Appeal Decision

Appeal Ref: APP/R5510/W/22/3298681

Neyland Court, Pembroke Road, Ruislip HA4 8NQ

- The appeal is made under section 78 of the Town and Country Planning Act 1990 against a refusal to grant planning permission.
- The appeal is made by Anslip (UK) Limited against the decision of London Borough of Hillingdon.
- The application Ref 76364/APP/2021/4604, dated 21 December 2021, was refused by notice dated 25 March 2022.
- The development proposed is construction of detached building to accommodate new management office accommodation above replacement parking spaces.

CLIENT	Anslip UK Ltd		
PROJECT	Proposed Management Office for 11-17 Neyland Court, Pembroke Road, Ruislip, HA4 8NQ		
TITLE	Proposed Block Plan

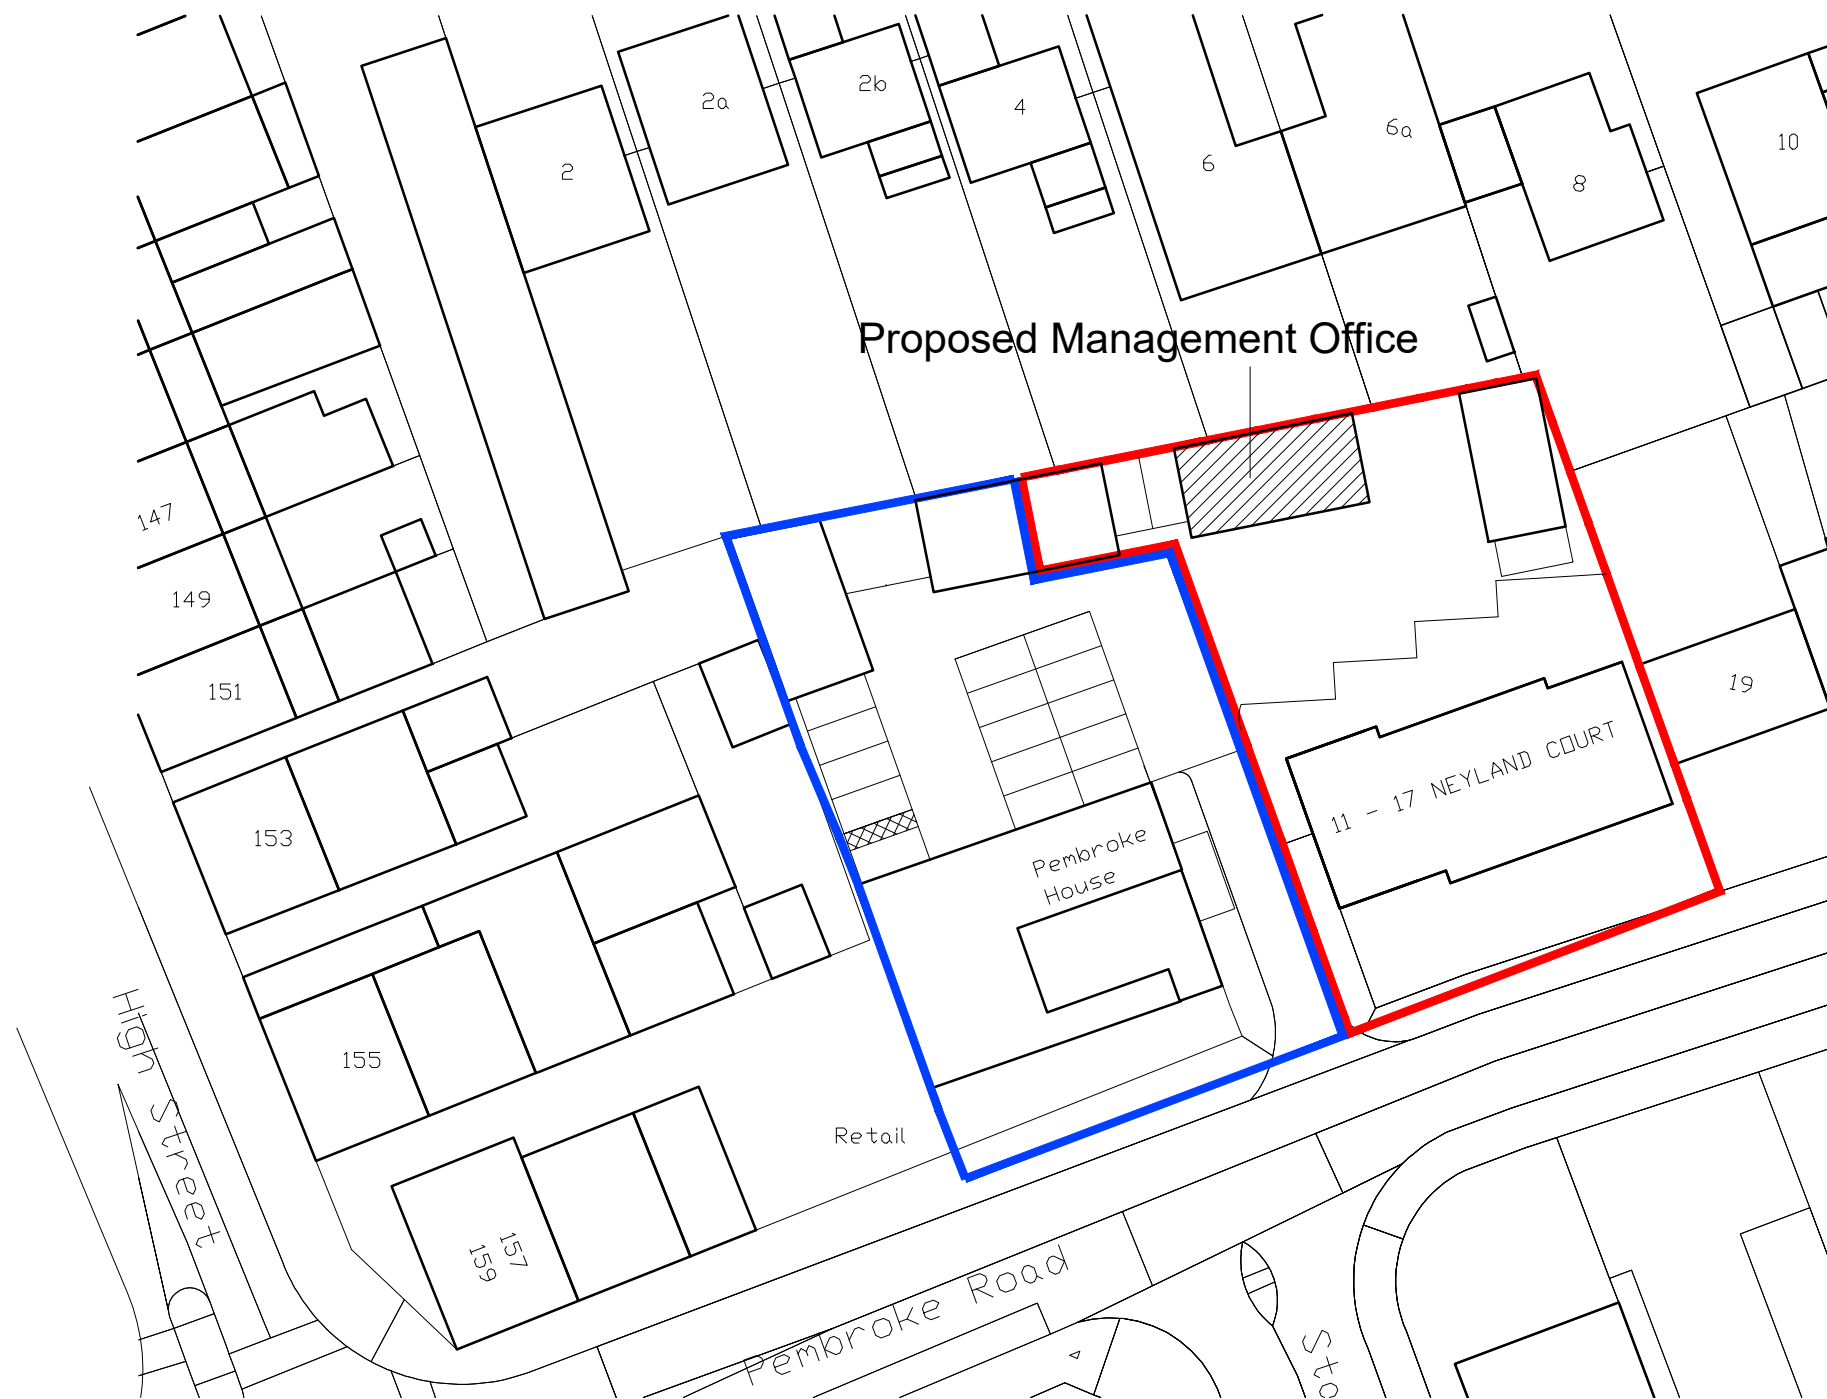
5. The appeal site forms part of a parking area to the rear of Neyland Court. The proposals would introduce a two-storey building on the northern boundary of the site. To the rear, of which, are the gardens of residential properties along Brickwall Lane. Of these properties, No 6 and No 6a Brickwall Lane (No 6 and 6a) are bungalows, positioned with their rear elevations close to the boundary with the appeal site and have small gardens.

6. The proposed building would have a box like form. Although the design with a flat roof would keep the overall scale and massing as low as possible, its width and height, in such close proximity to the garden and rear elevations of No 6, and to a lesser extent No 6a, would be an oppressive feature. Moreover, the lack of fenestration on the rear elevation, whilst ensuring that there would be no overlooking, would result in a somewhat stark appearance, exacerbating the harm. Overall, it would have a harmful effect on the outlook from these properties and their gardens.

11. The alterations to the parking and landscaped area would erode the external amenity space associated with the flats. Moreover, this would result in increased activity nearer the building from cars parking, doors closing and residents using the bin store. These incremental alterations would, cumulatively, erode the quality of the environment and exacerbate the harm from the proposed building.

Proposed - Elevations

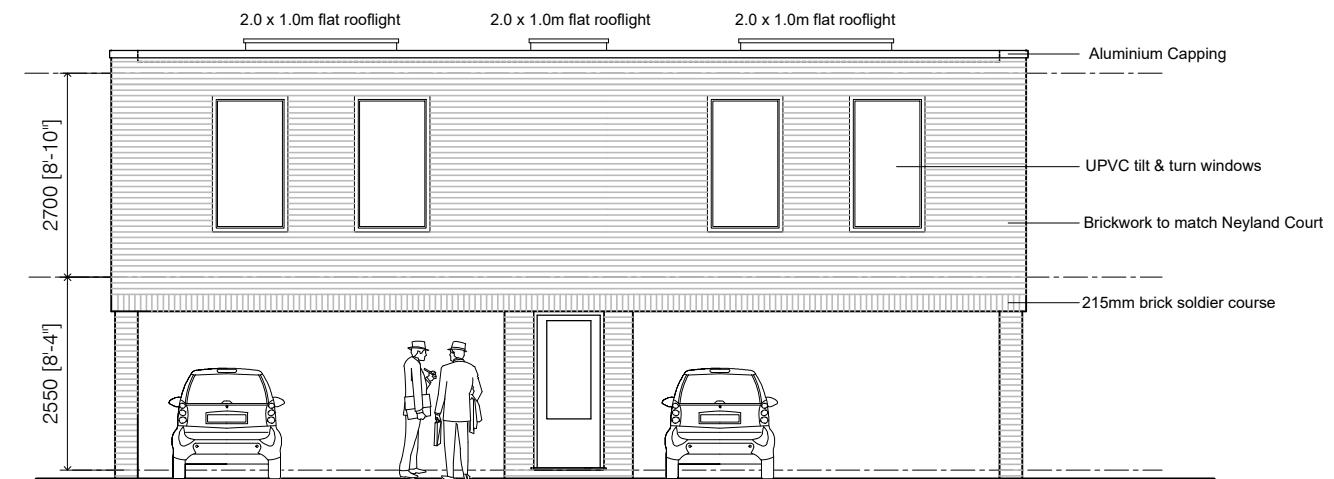
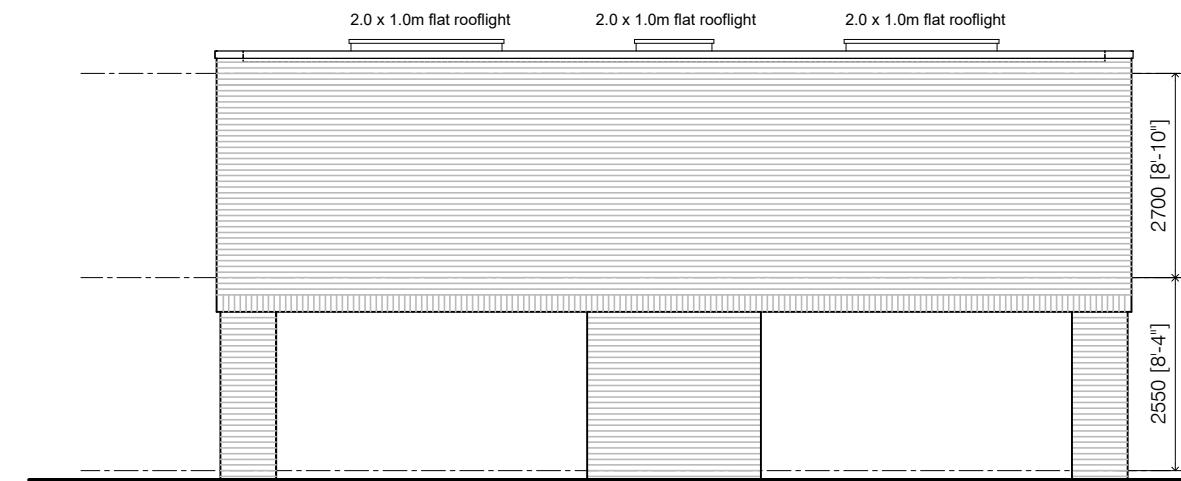
3. The appellant has also indicated that they would accept the introduction of fixed obscure glazed windows on the rear wall as an amendment to the scheme and has suggested that this could be secured by way of a condition. However, it is not the purpose of the appeal system to amend the design of proposals as this would deny occupiers of neighbouring properties the opportunity to provide comments, denying fairness and natural justice. For clarity, I have determined the appeal based on the plans before the Council when it made its decision. This includes Dwg No P.11.A.

10. The view of the proposed building from the flats within Neylands Court would be intimidating to occupiers of the flats, due to the reasonably short distance and directness of the view. Here, the proposed building would be a dominant structure with windows directly facing the flats. At this short distance there would be an unacceptable loss of privacy and outlook for occupiers of the flats.
